**HYDROLOGY DEVELOPMENT SECTION
DEVELOPMENT REVIEW BOARD MEMO**

DRB PROJECT NO: 1009243

**CITY OF ALBUQUERQUE
PLANNING DEPARTMENT
February 20, 2013
DRB Comments**

RE: Lot 15-A, Block 15, Mesa Grande Addition

SKETCH PLAT OF  
 LOT 15-A-1 15-A-2, BLOCK 15  
 MESA GRANDE ADDITION  
 SECTION 23, T10N, R3E N.M.P.M  
 CITY OF ALBUQUERQUE  
 BERNALILLO COUNTY, NEW MEXICO  
 FEBRUARY 2013  
 SHEET 2 OF 2

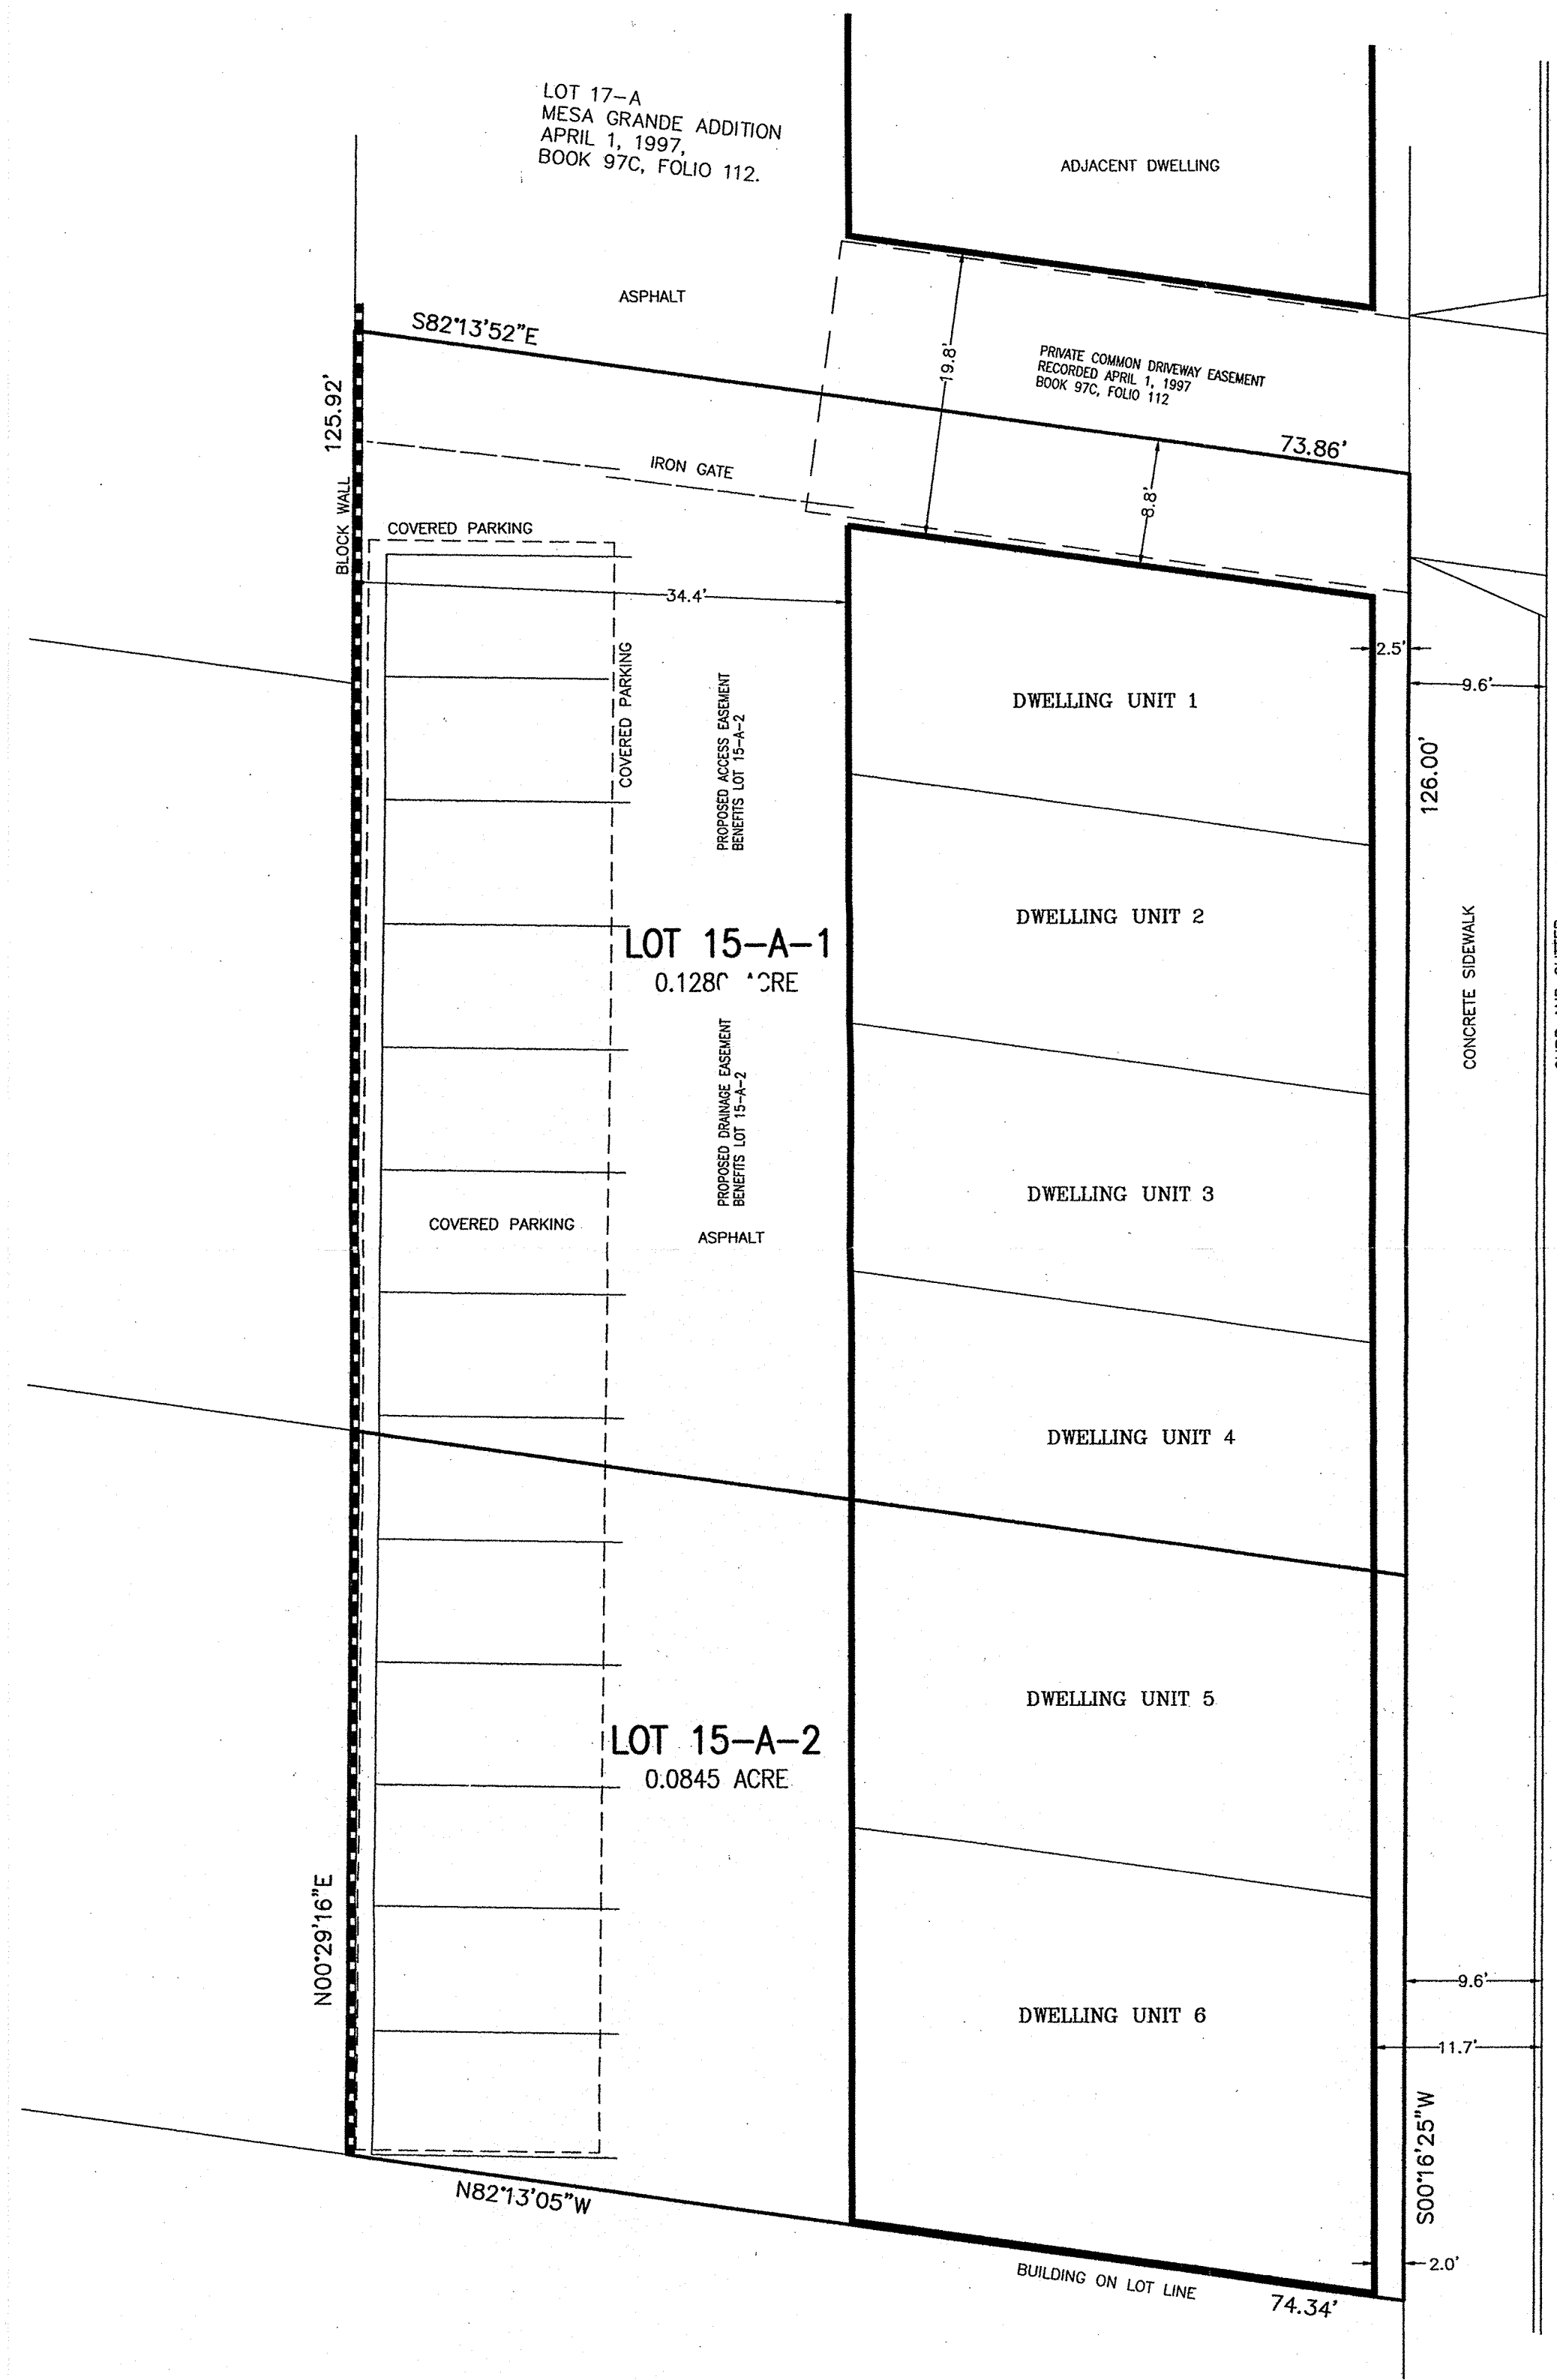
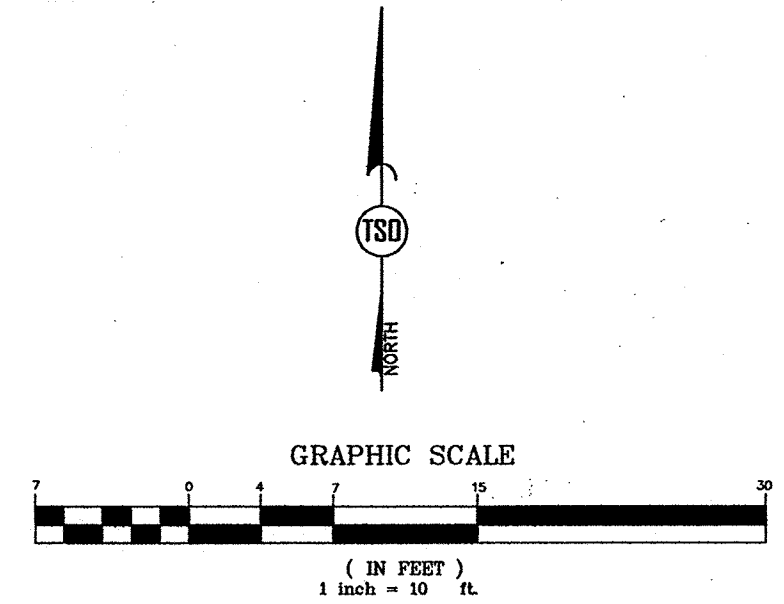
Clarify the location of the proposed access easement; is this a blanket easement?
Define the maintenance responsibilities for the proposed access easement.

Please provide a copy of the referenced 1997 Common Driveway Easement with Lot 17-A. Remove Zoning Note No. 9 from final plat.
